**MODIFICATION REQUEST:
Residential Buildings R8 and R9, Barangaroo South
MP 11_0002 MOD 1**

Secretary's Environmental Assessment Report
Section 75W of the
Environmental Planning and Assessment Act 1979

February 2015

1 Typical Retail Facade Option A_Fixed Glazing
1 : 50

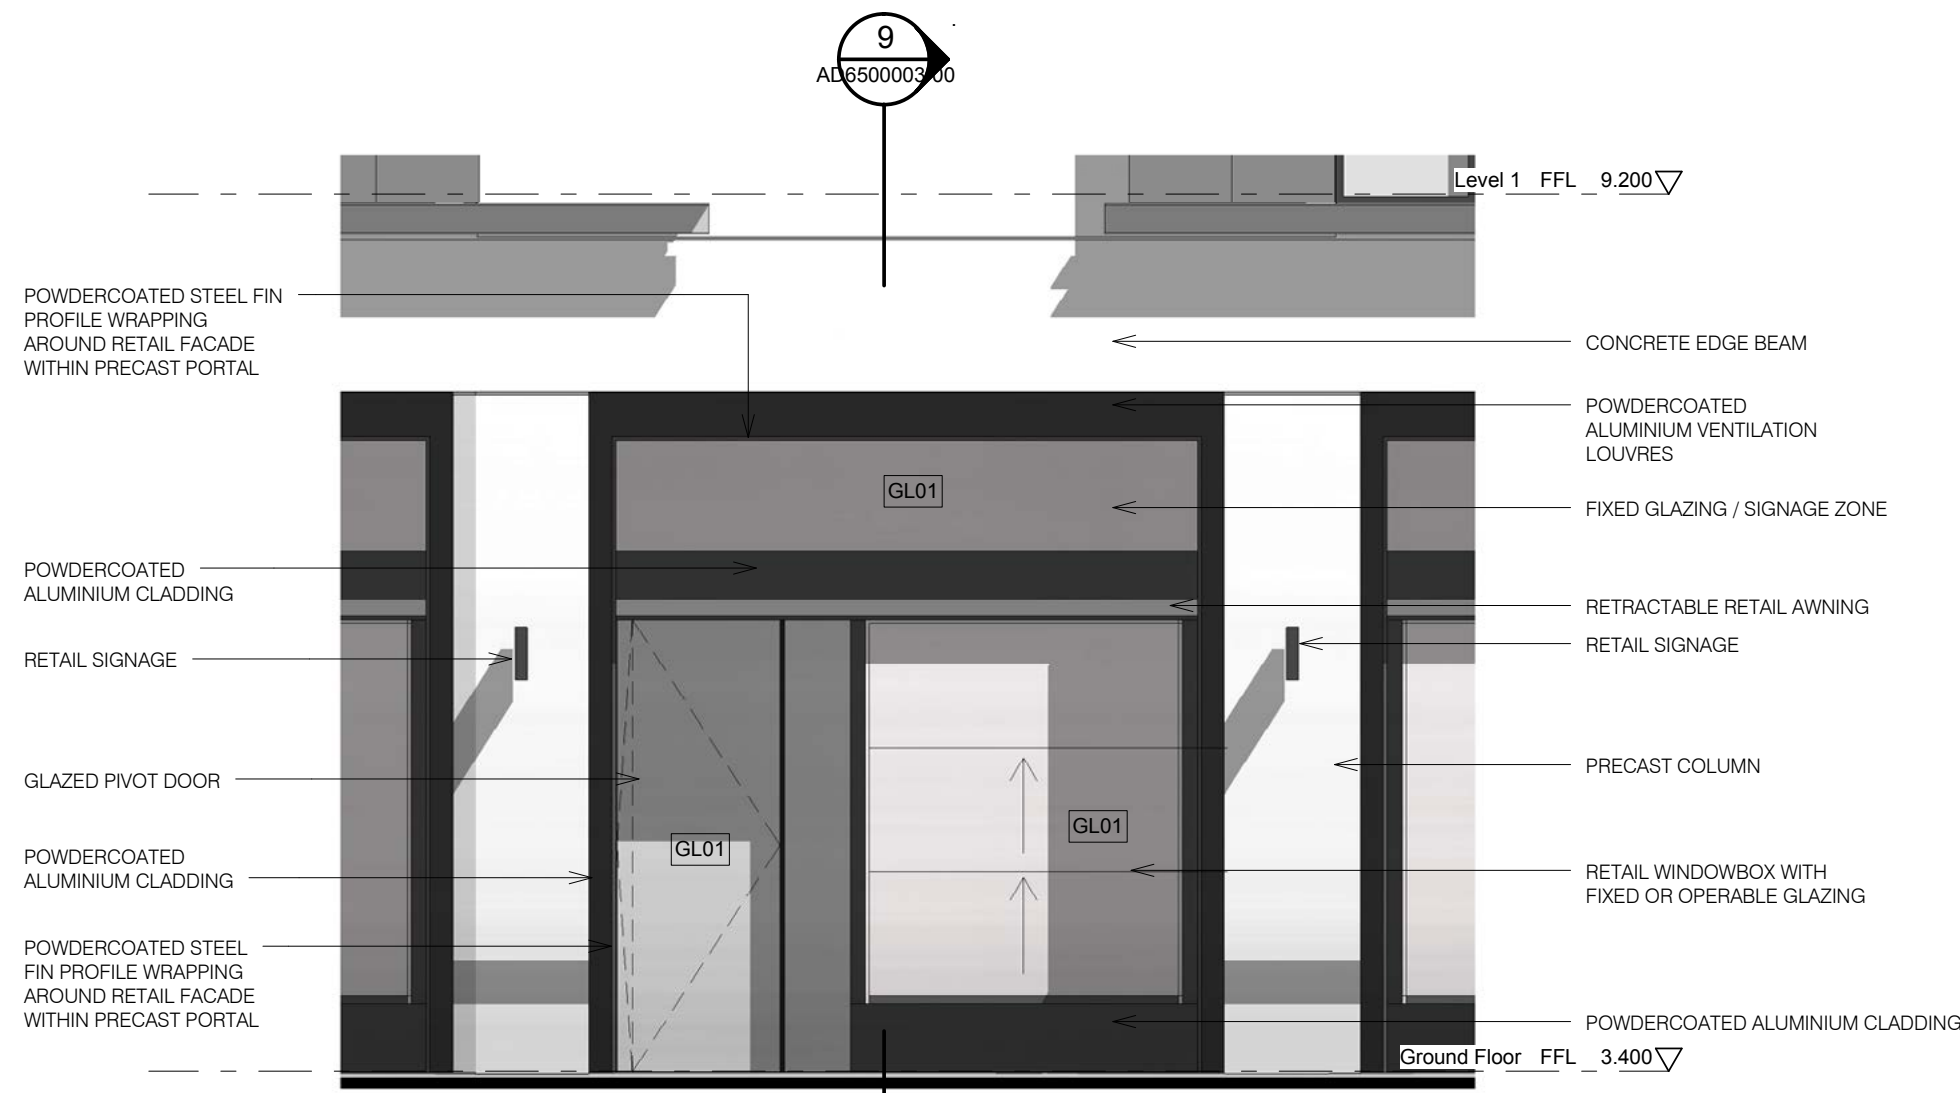
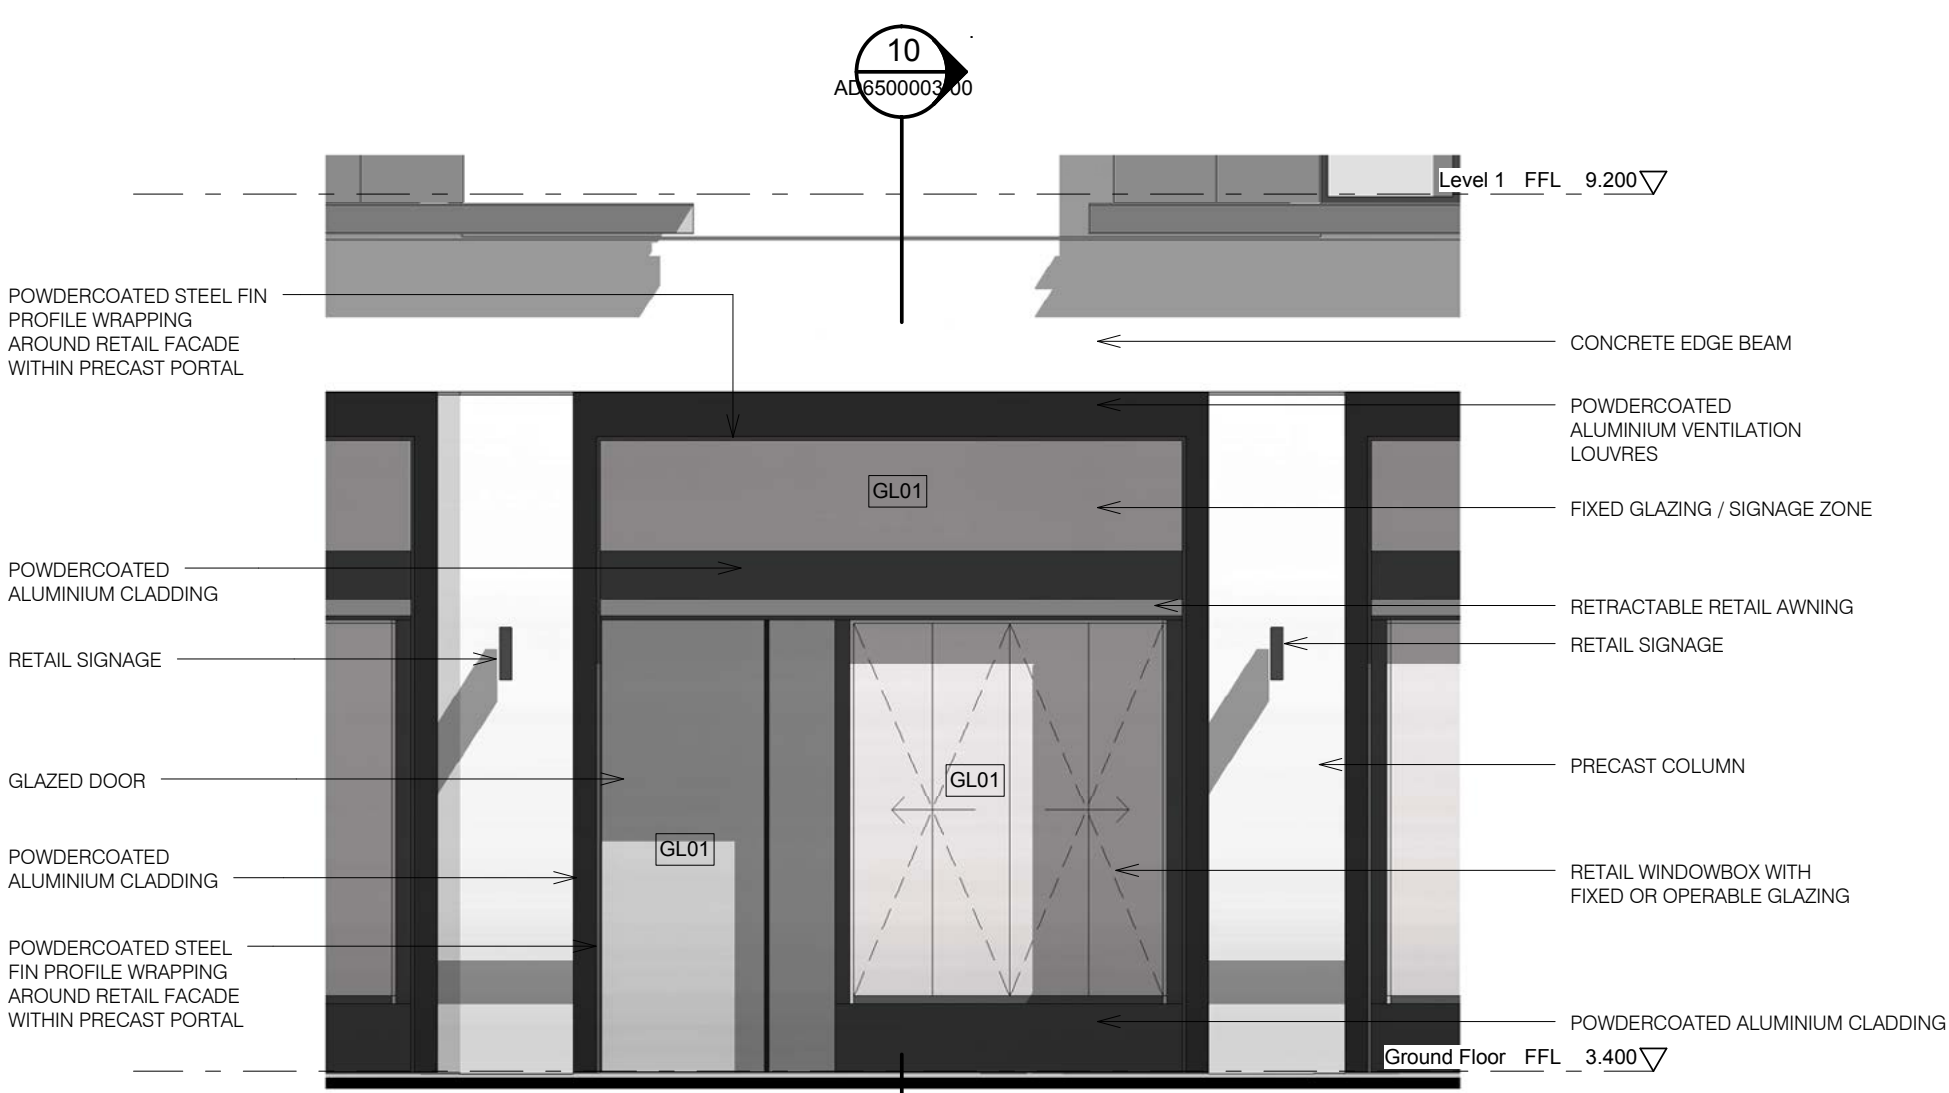
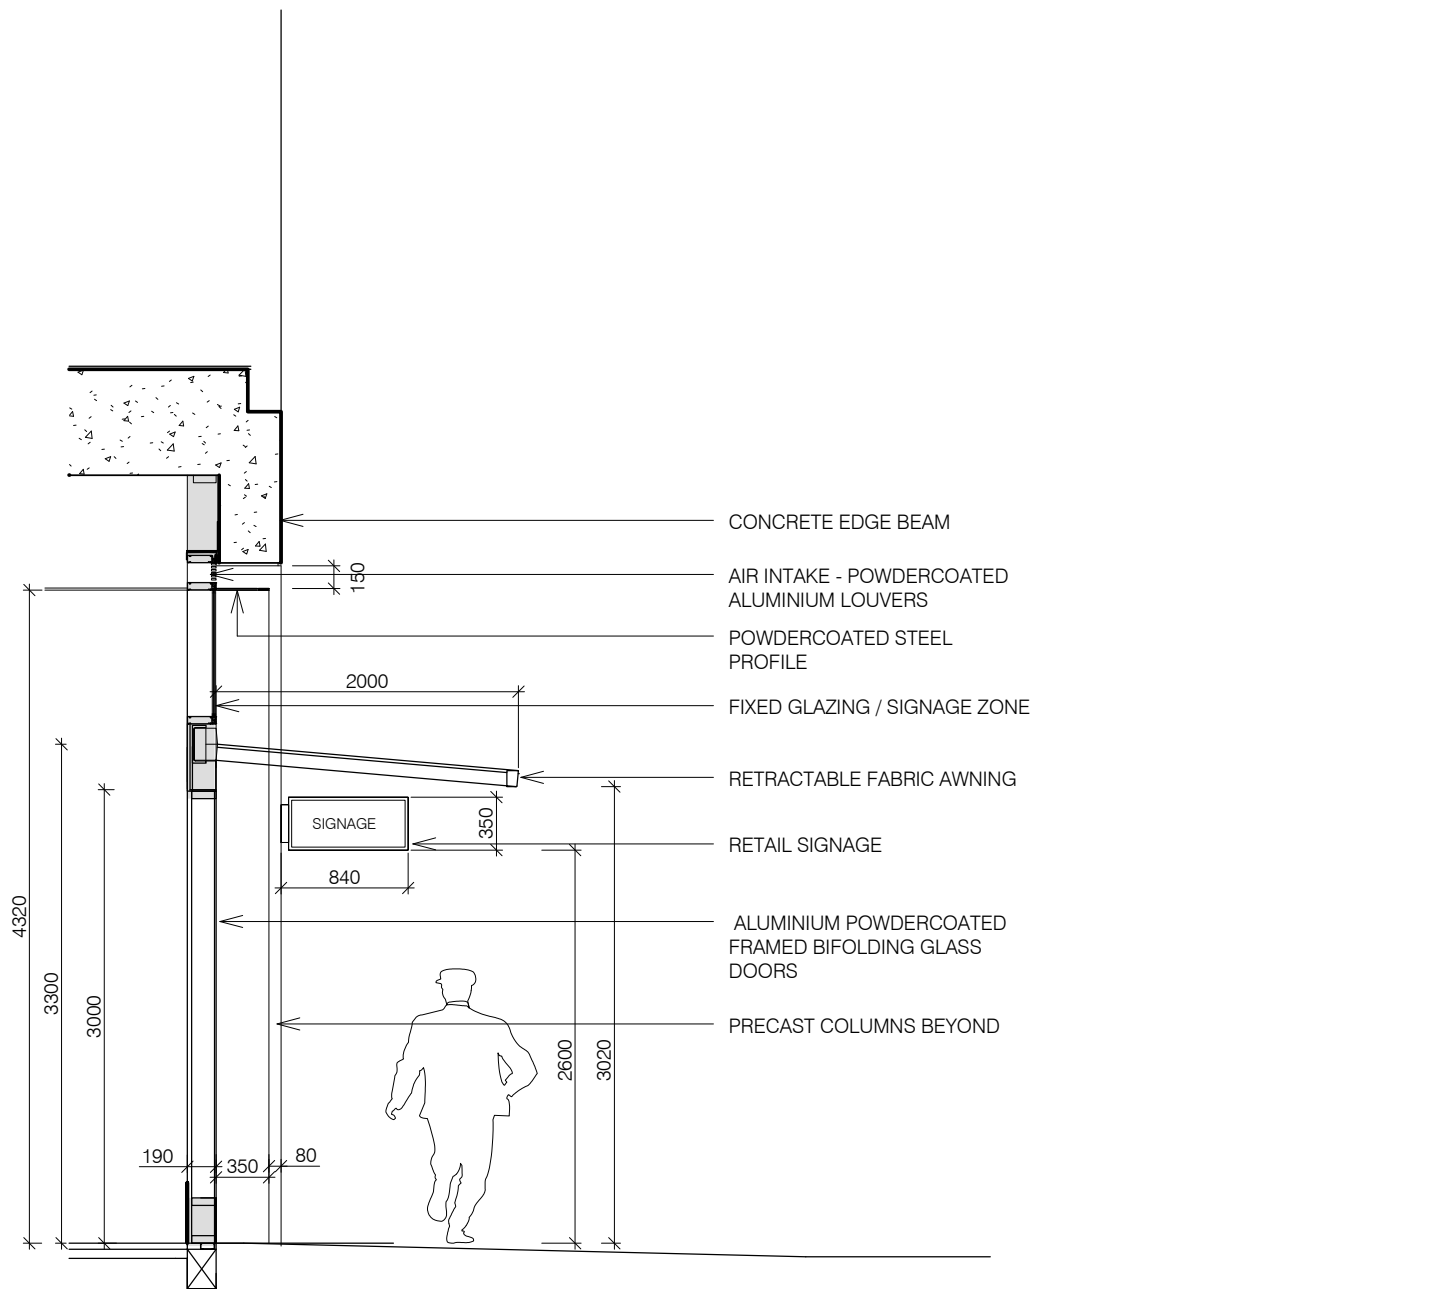
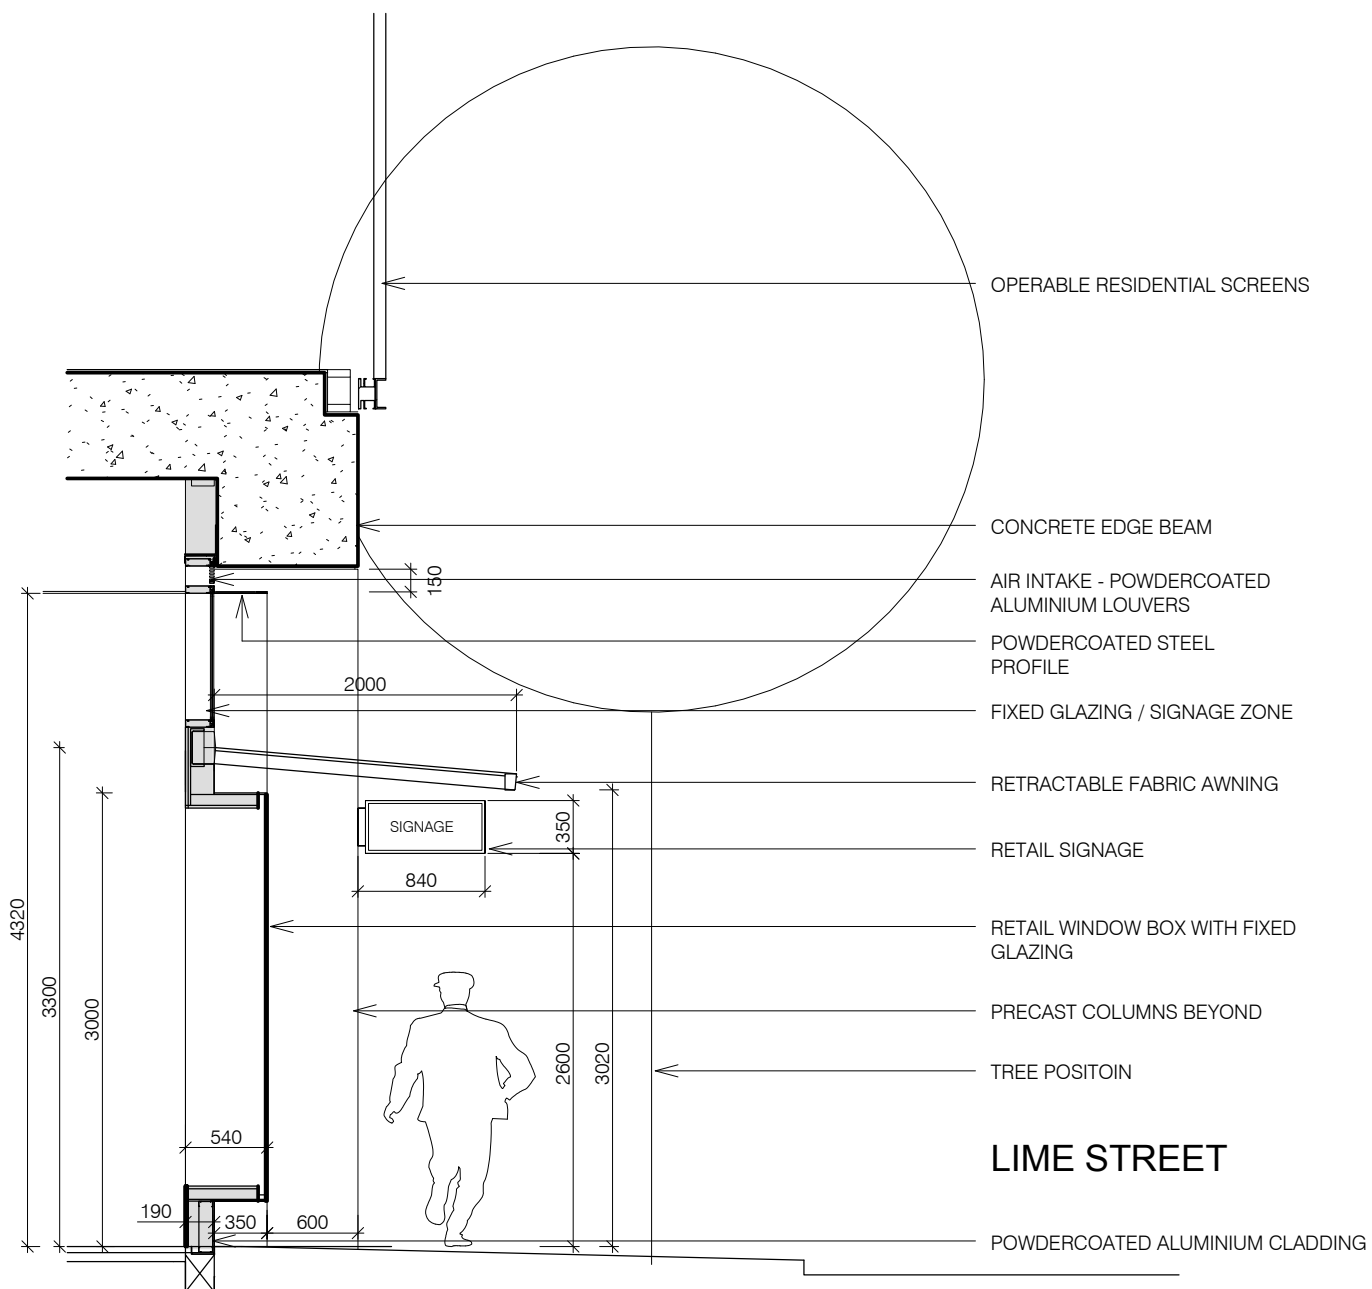
Council raised no objection to the proposed range of retail shop front designs, however, the Government Architect requested further clarification regarding the method for selecting shopfront designs for each of the ground floor retail tenancies. The Department also sought clarification from the Proponent as to whether the retail shop fronts would be constructed under the project approval or as part of the future fit-out applications for the ground floor retail tenancies.

The RTS identified that the retail shop front designs proposed in the modification application are currently only indicative, and that the final detailed designs would be selected by the future tenants according to their design and operational needs. The RTS also identified that the final design of the retail shop fronts would be either undertaken by the Proponent, subject to further approval by the Secretary under the project approval, or the subject of separate future applications by the future tenants themselves. Additionally, the Proponent sought to introduce a new Statement of Commitment (SOC) to secure a framework for the future assessment of the shopfronts for the other elevations (north, south west). The proposed SOC includes general design parameters for each of the shopfronts, namely:

The Department considers that the indicative retail shop front designs with various combinations of glazing and pivot entry and bi-folding doors would generally provide an acceptable outcome for the ground floor retail areas of the buildings fronting Lime Street. The Department also acknowledges the need to provide flexibility for future tenants to tailor the final design of the shop fronts to their needs, and is generally satisfied with the proposed SOC and general design parameters for the shopfronts for the other elevations. Notwithstanding, to provide clarity in the approval, the Department has recommended modifying a number of conditions to specify that no approval is granted to the
